## Kittitas Reclamation District

September 1, 2020

RE: Project File No. SE-20-00003 (Brown and Jackson)  
Kittitas Reclamation District Comments

**BROWN & JACKSON**  
 Land Application Site  
 Preliminary  
 Site Map  
 Kittitas County  
 Washington

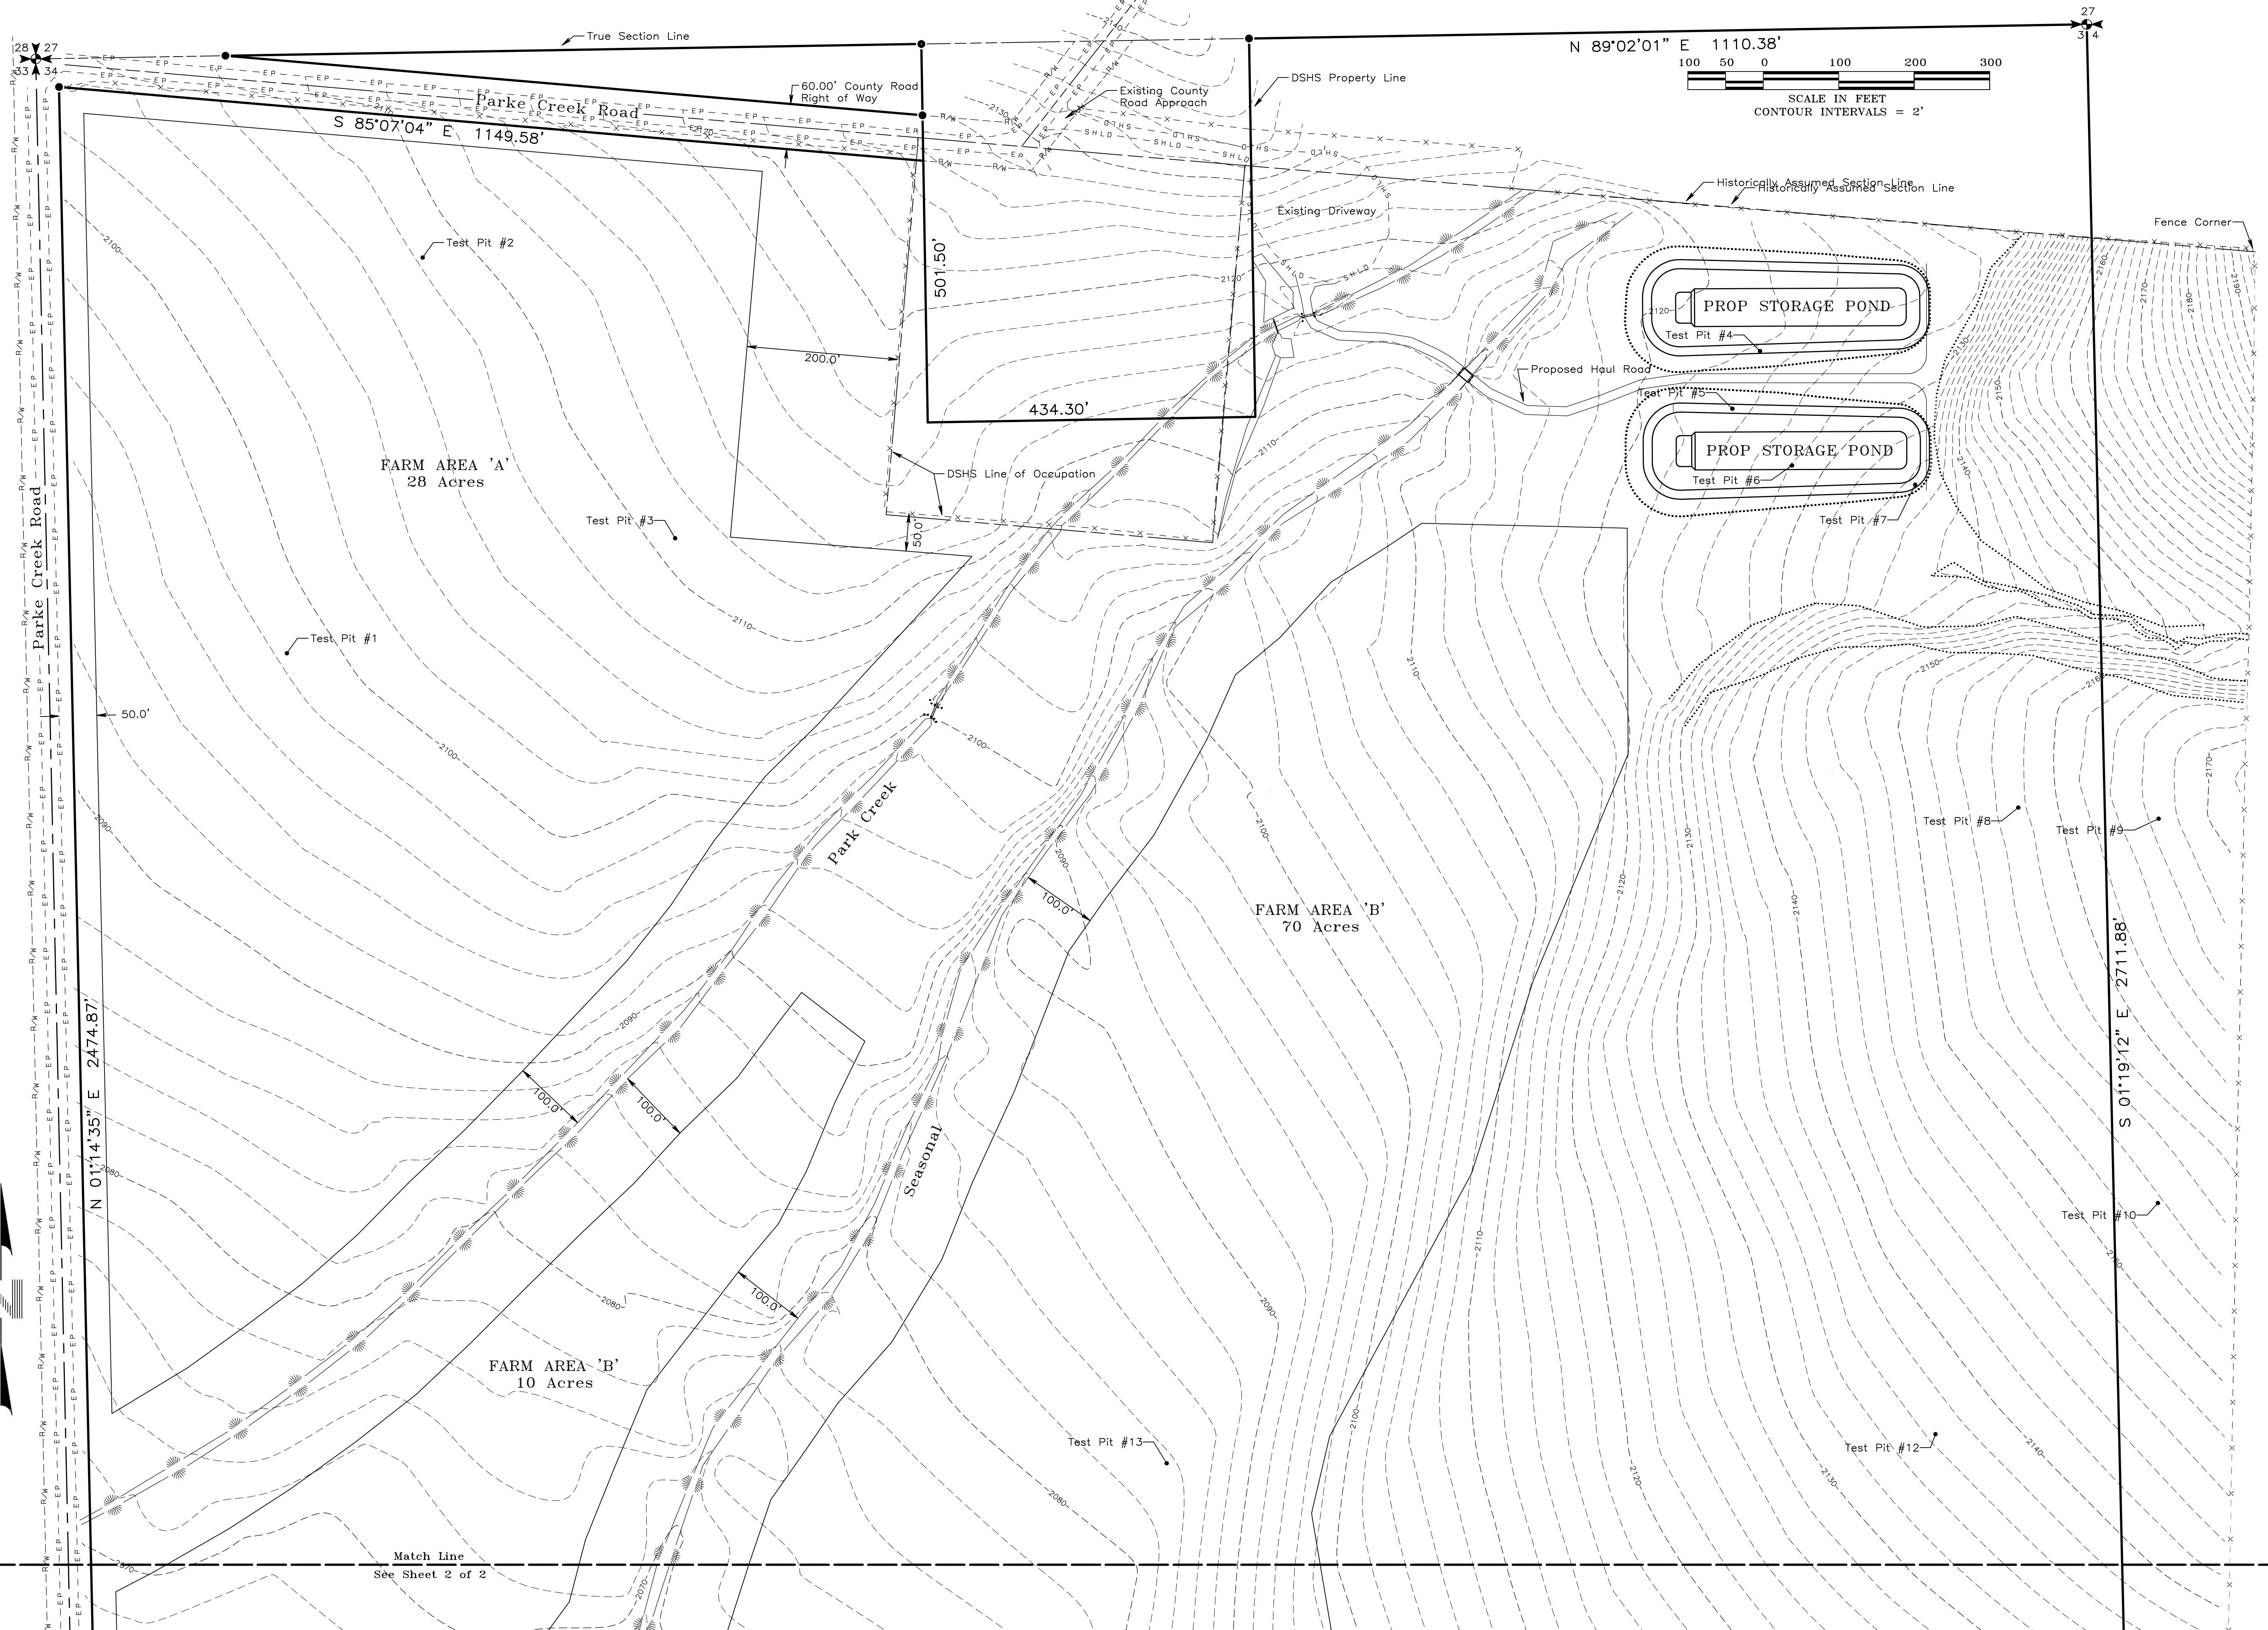
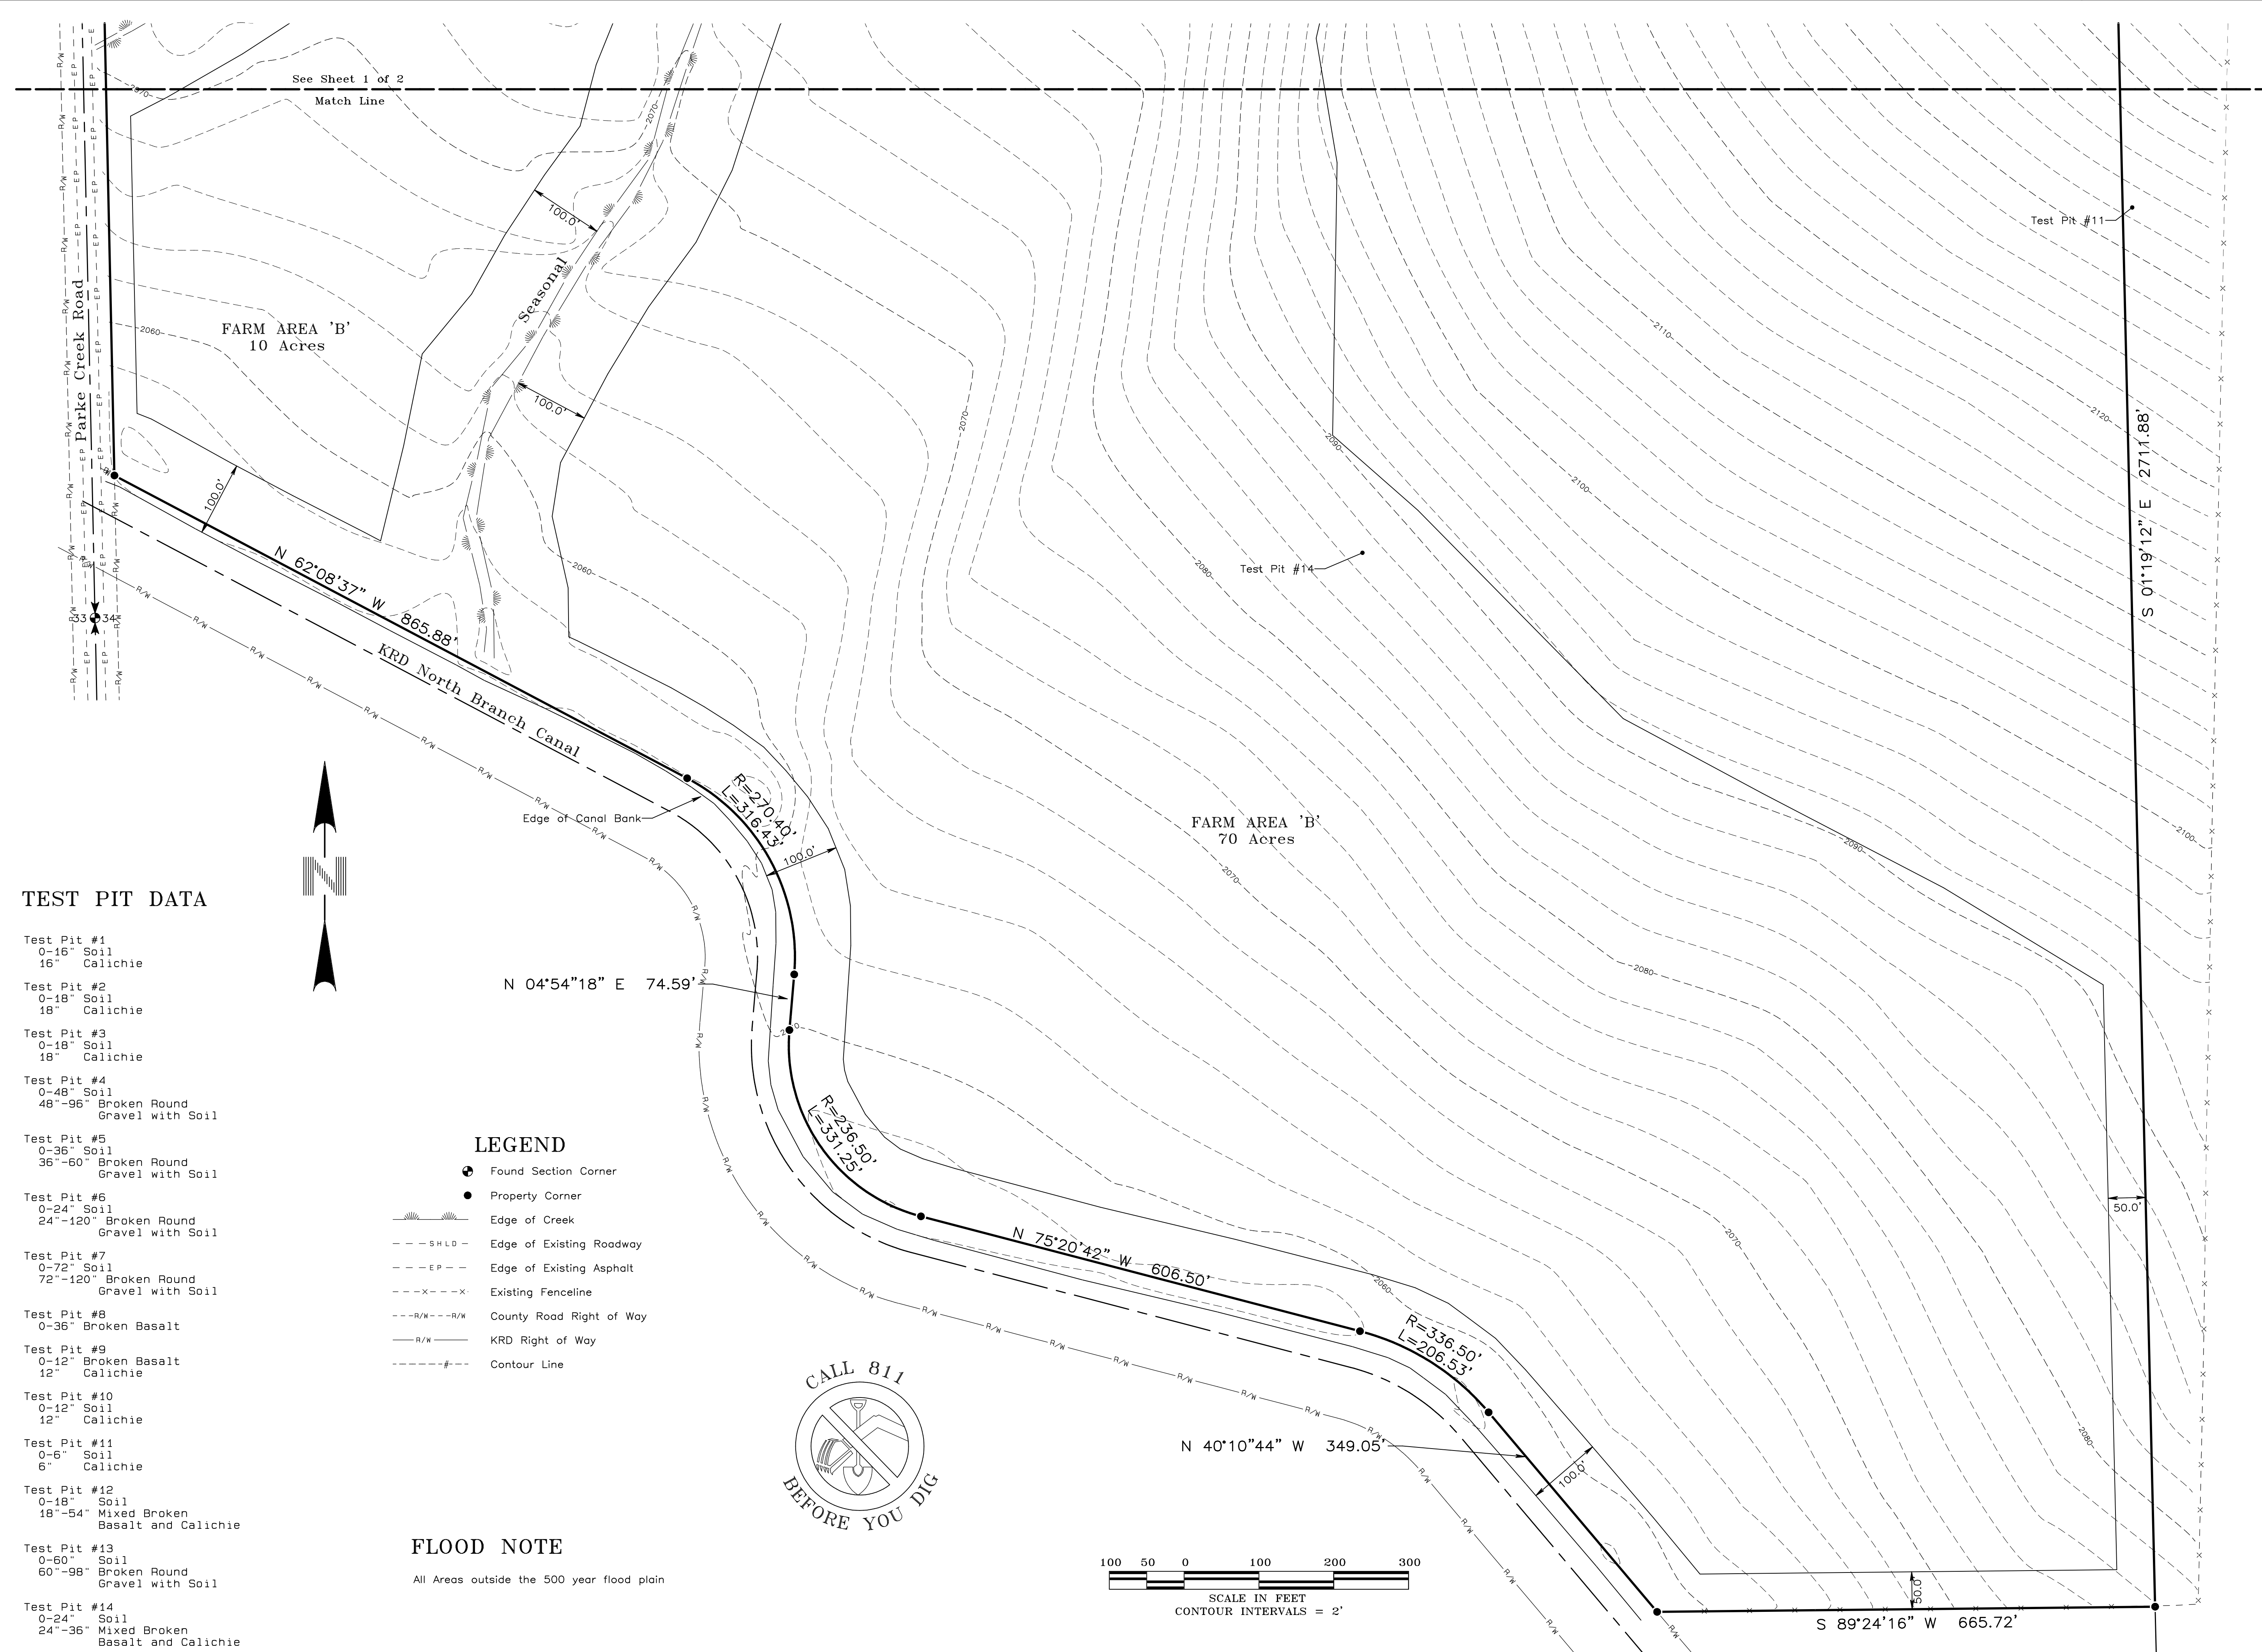
Section B.3.a.1 – This section and the included site map do not accurately describe all of the surface water features, such as streams and irrigation ditches. The site map included in the July 30, 2020 Western Pacific Engineering and Survey addendum improperly characterizes

Parke Creek's location with respect to the application fields and proposed storage ponds. There are three waterways that bisect the proposed project site, and each of them undershoot the KRD canal. The checklist fails to identify all of the surface water features, describe the type, or state what stream or river it flows to. At least two of the surface water features are in close proximity to the proposed septage ponds.

Section B.3.a.2 – The Proposal indicates all planned work is located more than 200 feet from nearby waterways. However, the site map provided in the addendum shows potential application area as occurring within 100 feet of the Parke Creek seasonal channel and the KRD North Branch canal, which is down-gradient of the proposed use area. Potential impacts to all surface water and the unlined canal after land application are not covered. There is no analysis of the potential for surface water contamination and transfer to the KRD canal.
